TOWN AND COUNTRY PLANNING ACT 1990

PRIOR NOTIFICATION

Reference:	H23-0345-22	Date of Decision:	13th May 2022
Applicant:	Mr & Mrs D Ford Carlton Lodge Oxcroft Bank Shepeau Stow Spalding PE12 0TY		
Location:	Carters Farm Oxcroft Bank Shepeau Stow Spalding		
Description:	Change of Use of Barn into Residential Dwelling

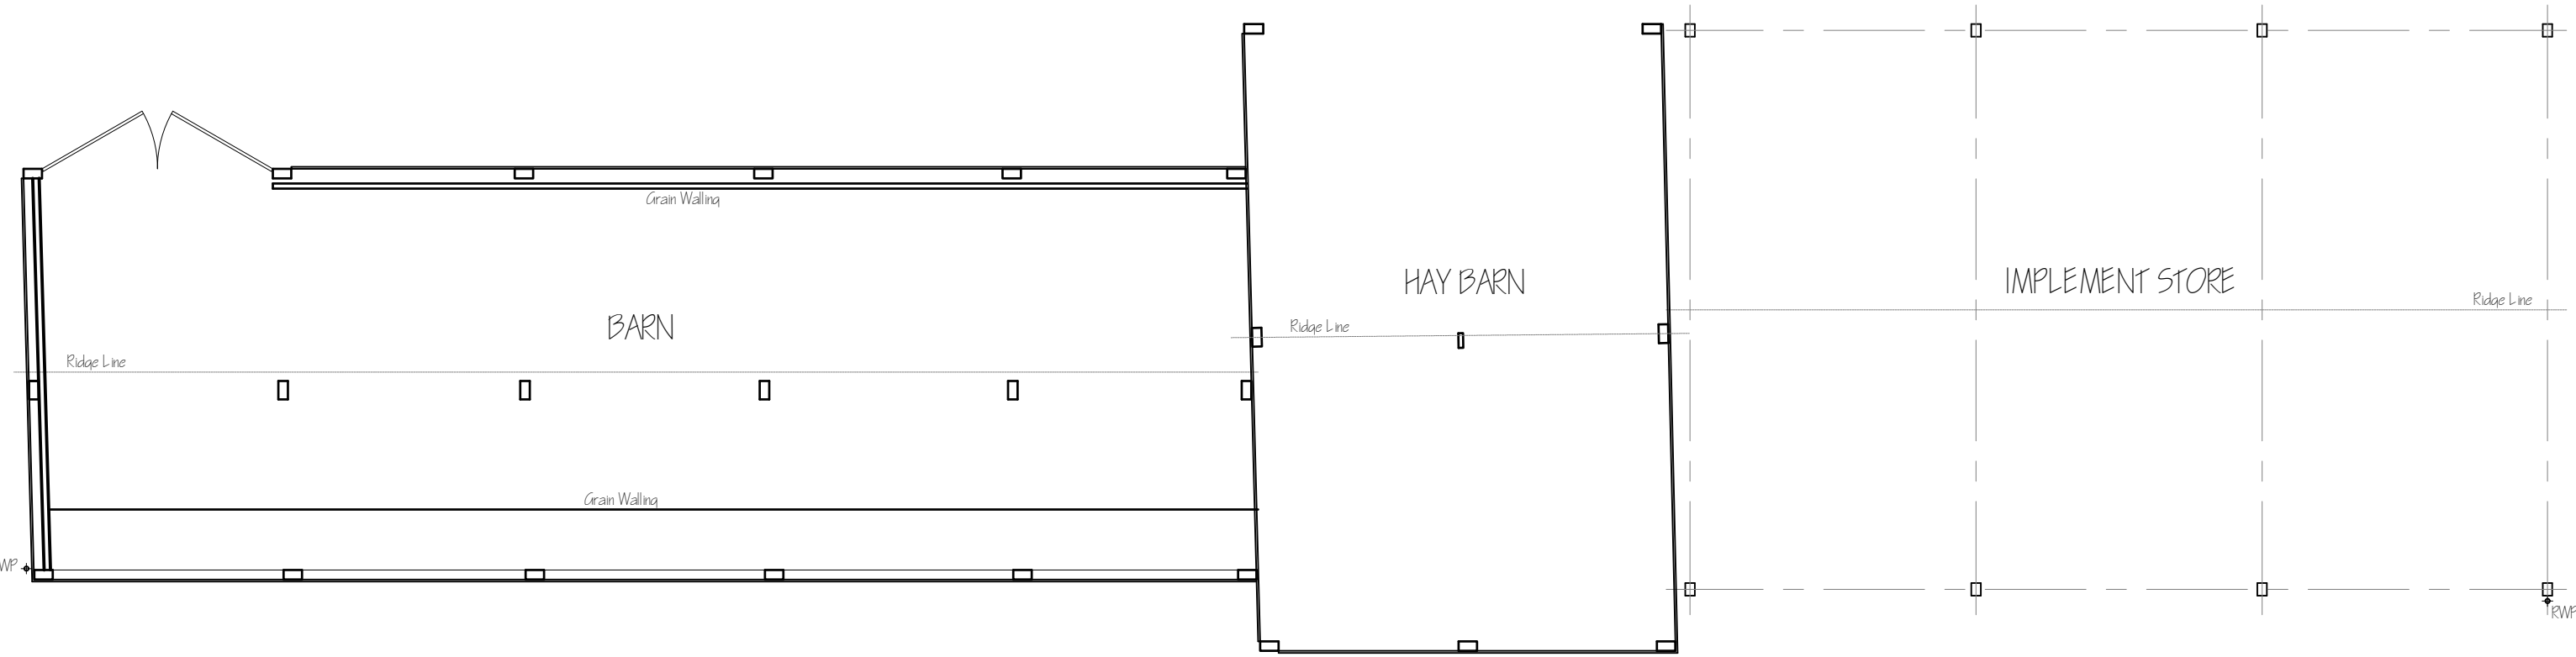
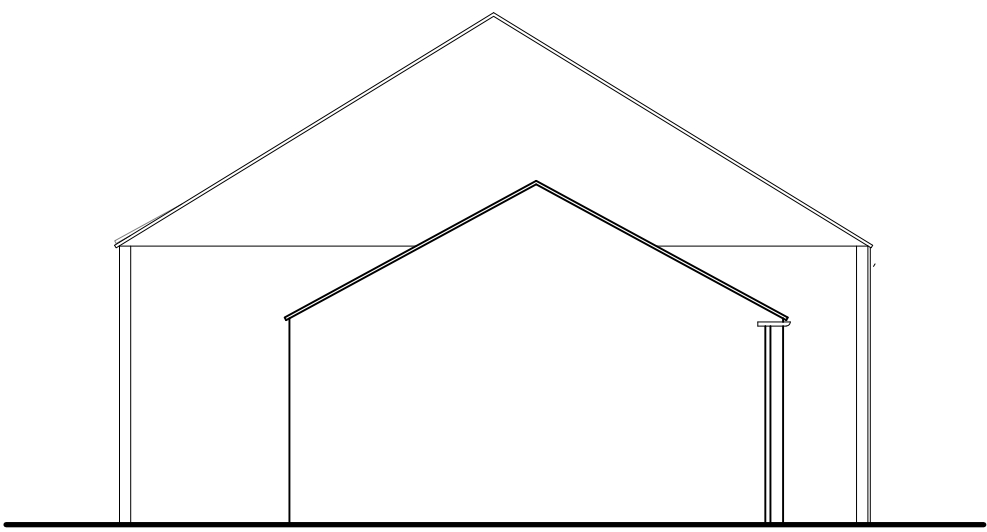
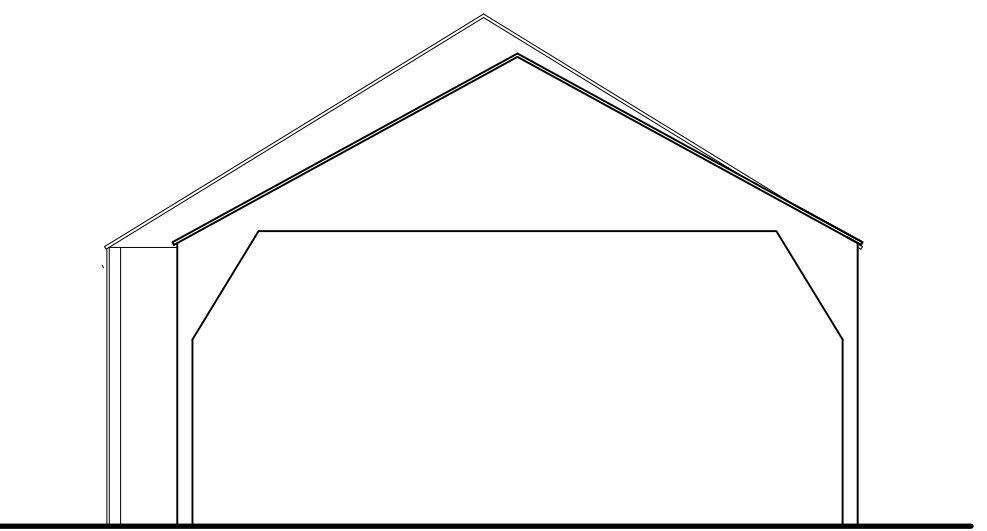
- 1 The building is not considered to be capable of being converted to residential use without building operations that would be so extensive as to go well beyond the scope of the operations permitted by Class Q and would amount either to substantial rebuilding of the pre-existing structure or, in effect, the creation of a new building.

Moreover, the extent of works exceed that which is permissible under Class Q which only permits minor works reasonably necessary to convert the building. The installation of a floor into the open element of the barns and the creation of sides on a previous open barn go beyond the extent of Class Q.
